Application No: P/135/25/DOC

We would like to raise our concerns regarding the proposed plans to use the access point used by Windmill Barn, Commonmead Barn and The Paddock as the heavy goods vehicle exit point from the new Bargate site referred to as Land West of Pagham Road, Pagham PO21 3PY. We also have concerns regarding the revised CEMP regarding traffic approaching the site from the East.

7. Off site traffic Management

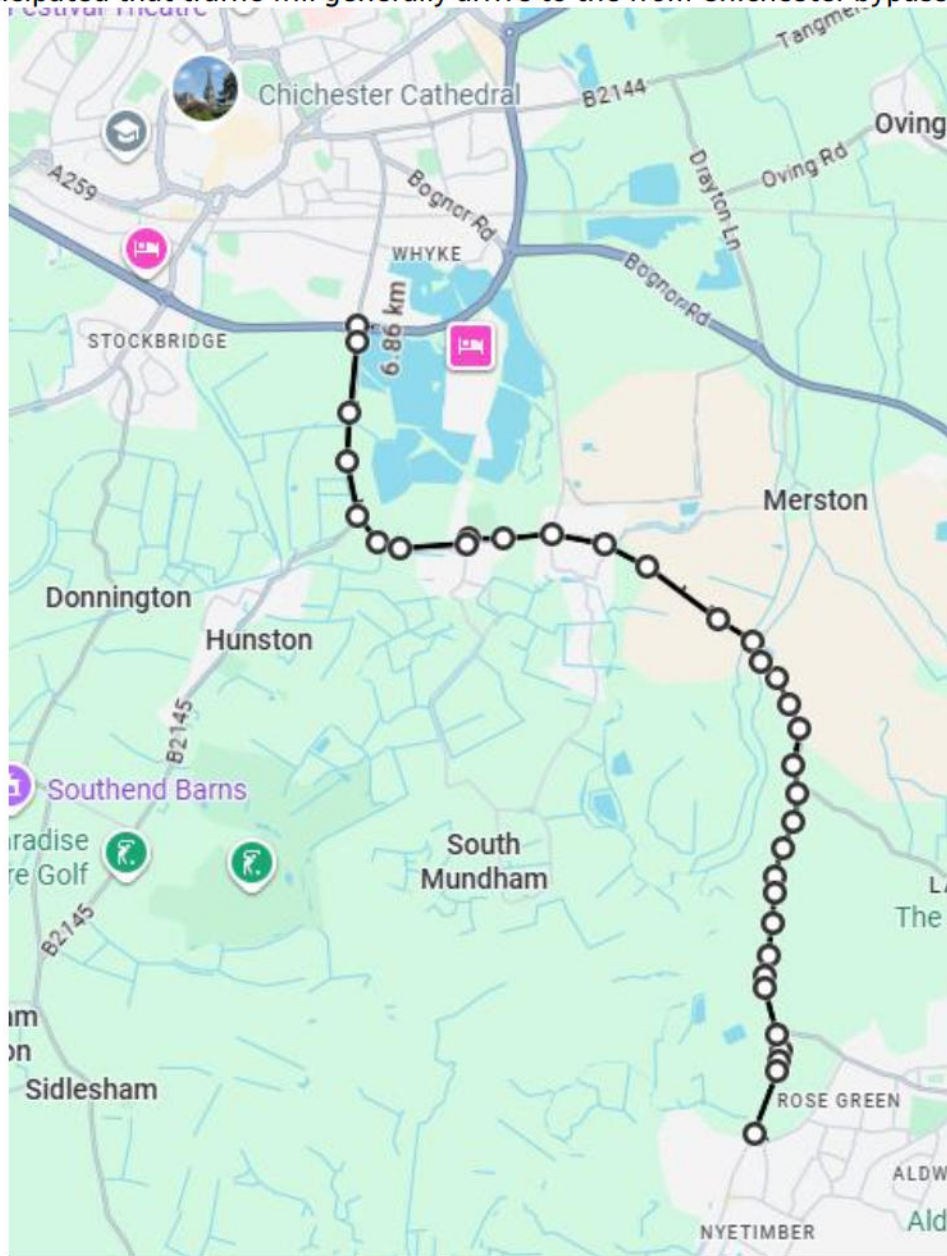
- We have major safety concerns regarding the haul road access point onto a shared residential driveway which is used by us to enter and leave our properties. The CEMP states that there will be 77 heavy vehicle movements per week and will also generate the need for circa 40 cars **per day**. With the addition of an occasional fleet of up to 10 tipper trucks on a 6 load turnaround. This will create a significantly increased danger of collision as the access is fairly narrow, with established tall shrubbery which partially blocks the view when turning in from the 60 mph Pagham Road and leaving from the access point to Pagham Road. **Furthermore, this access point is also used by us as pedestrians including a wheelchair user, there is no footpath and is our ONLY access point.**

We request that the exit haul road is extended to allow all site vehicles to access and exit using the newly created entrance, leaving our entrance free and easily accessible by us and should the need arise, emergency vehicles too.

Any traffic arriving from the East will be directed from the A259 along rowans way

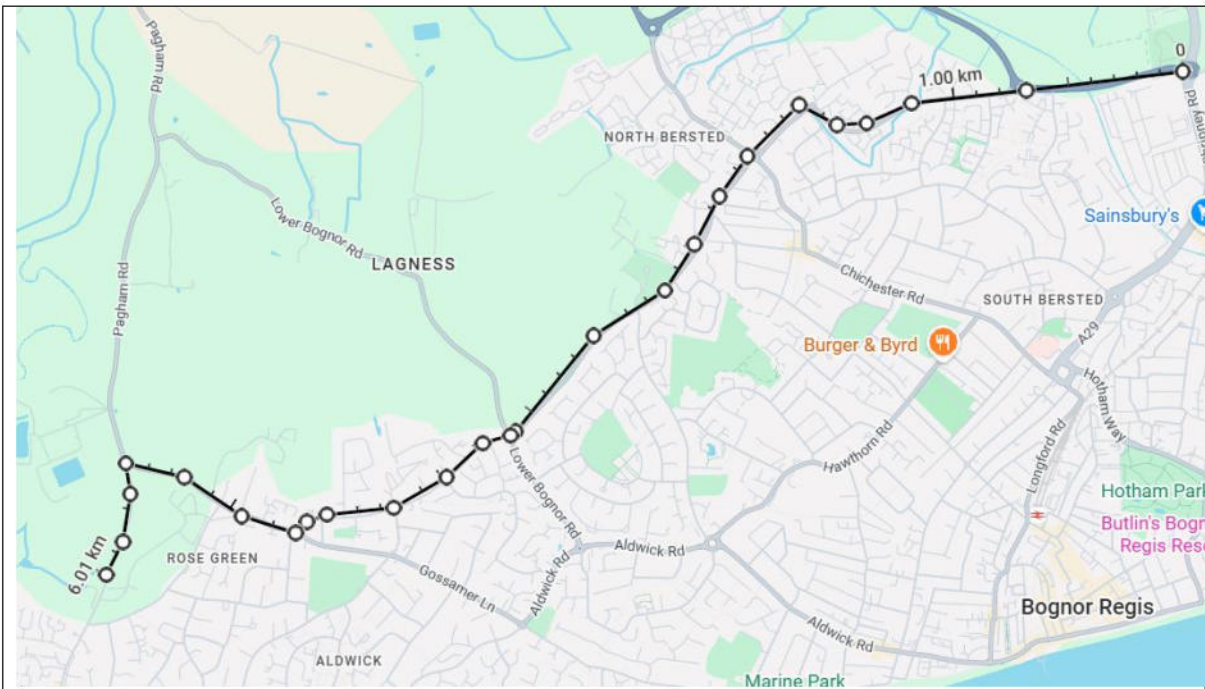
- The revised CEMP shows a routing arrangement for vehicles arriving and departing from the East. This includes a route along Rowan Way & onto North Bersted Street, this is a narrow residential street that includes a busy child's nursery surely not an ideal route for heavy goods vehicles. The route then continues until exiting left from Sefter Road onto Pagham Road (ariel photo below). This junction has a turning tighter than 90 degrees onto a 60 mph 'B' road, a lorry will have to use both sides of Sefter & Pagham Road to achieve this turn. Traffic from Pagham is nearly blind to Sefter corner and in addition there are bus stops either side of the road which are in constant use by Barfoots workers exiting the designated footpath opposite the junction. *We are astounded that WSCC highways have approved this!*

12. Control of Mud

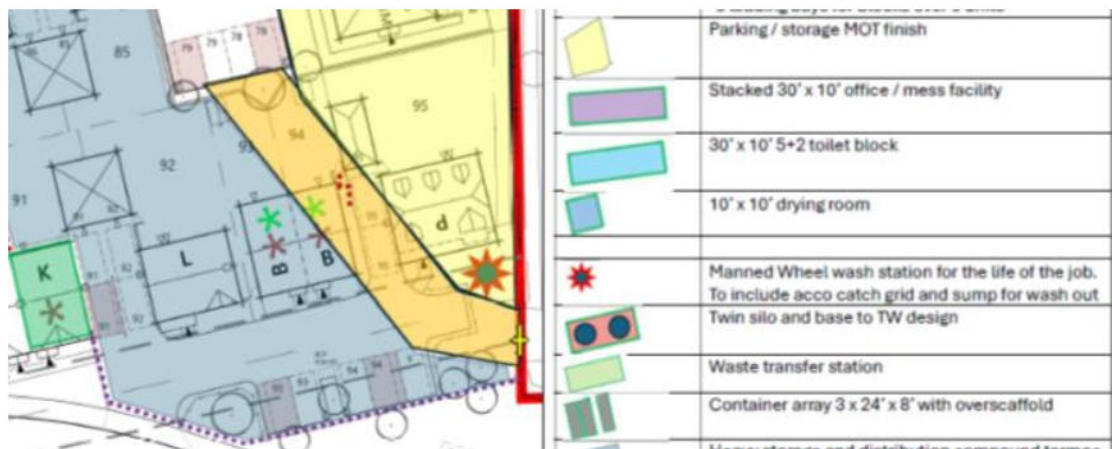
- We also have concerns about the mud and general debris that will be left following the heavy goods vehicles leaving the building site. The point raised in the traffic management plan states that wheel washing will be made operational as the need arises suggests that this will only be done when conditions are very poor. The current work on the site to the North of Hook Lane and East of Pagham Road also have the same issue with mud being left on the road. As this was a little distance from us, it was far less of a concern, especially as the road was regularly cleaned to remove the debris, but for us, as our entrance is not on the public highway, the mud will adversely impact the immediate area including much of our gravel drive, and by association also our vehicles and potentially us as the pedestrians too.
